From: Simon Davis
Sent: 14 June 2019 12:24
To: Planning.Responses
Subject: FW: Planning Consultation on FP/42/19/DOC
Attachments: 17094-PL-2-50 RevA - External Works.pdf; 5782-01T Engineering Layout.pdf; 5782-23B Construction Details.pdf; HH04 Wellers Close Soft Landscaping.pdf; 0321_5782_SUDS Management Maintenance Plan_RevA_2019.06.13.pdf

From: Lauren Wiltshire [REDACTED]
Sent: 11 June 2019 13:45
To: Simon Davis [REDACTED]
Cc: Laura Gibbons [REDACTED]
Subject: RE: Planning Consultation on FP/42/19/DOC

Rev.	Date	Note	Author	Checked
A	11/06/19	De-mountable fence indicated to rear of Plots 12 - 14	RR	JP

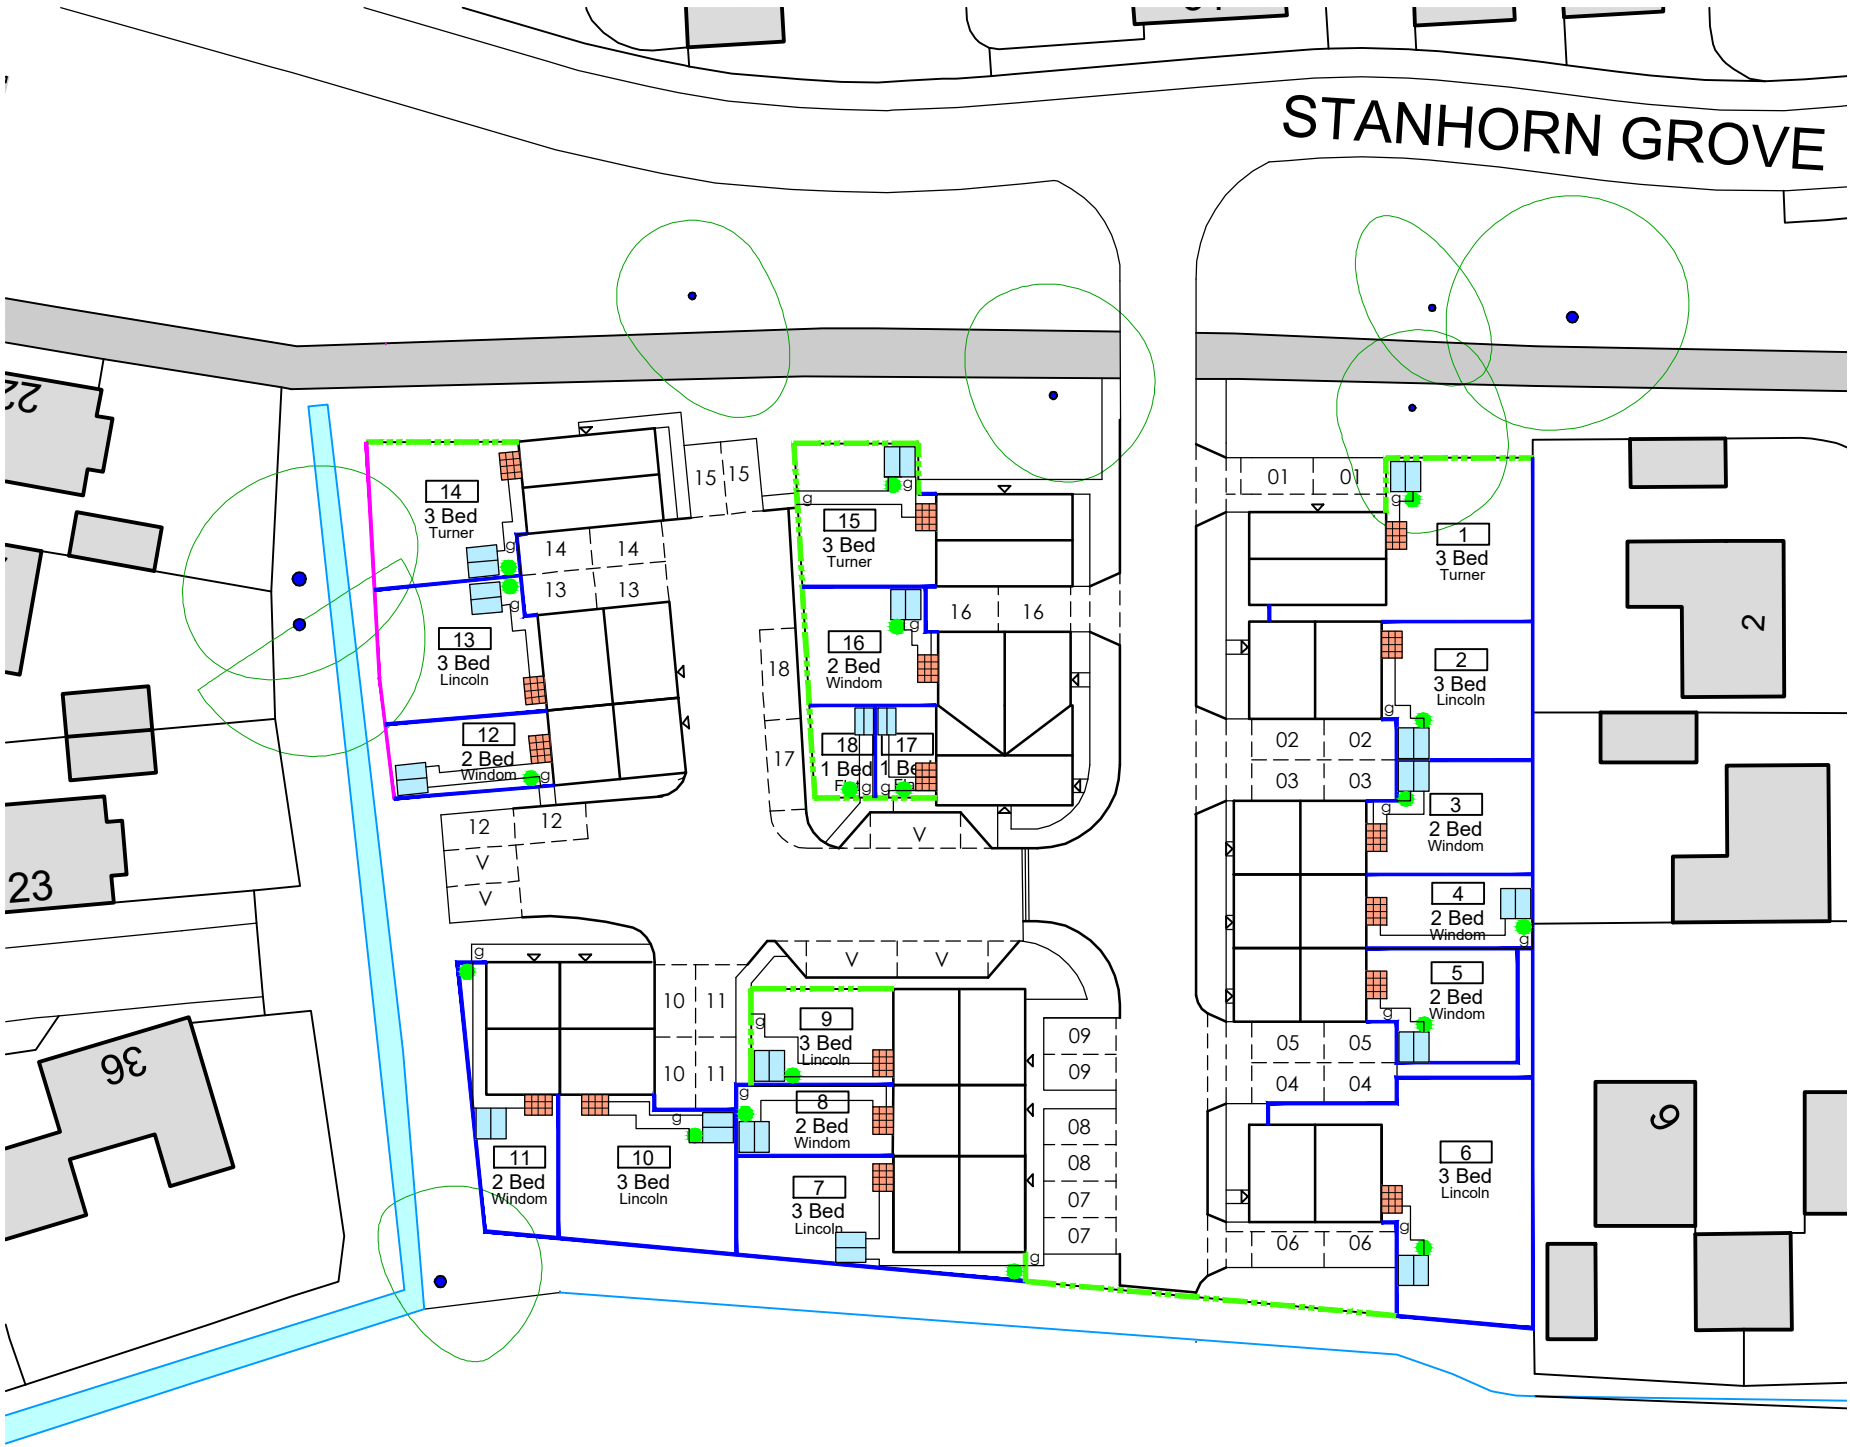
Please find attached the updated layouts showing demountable fence as agreed.
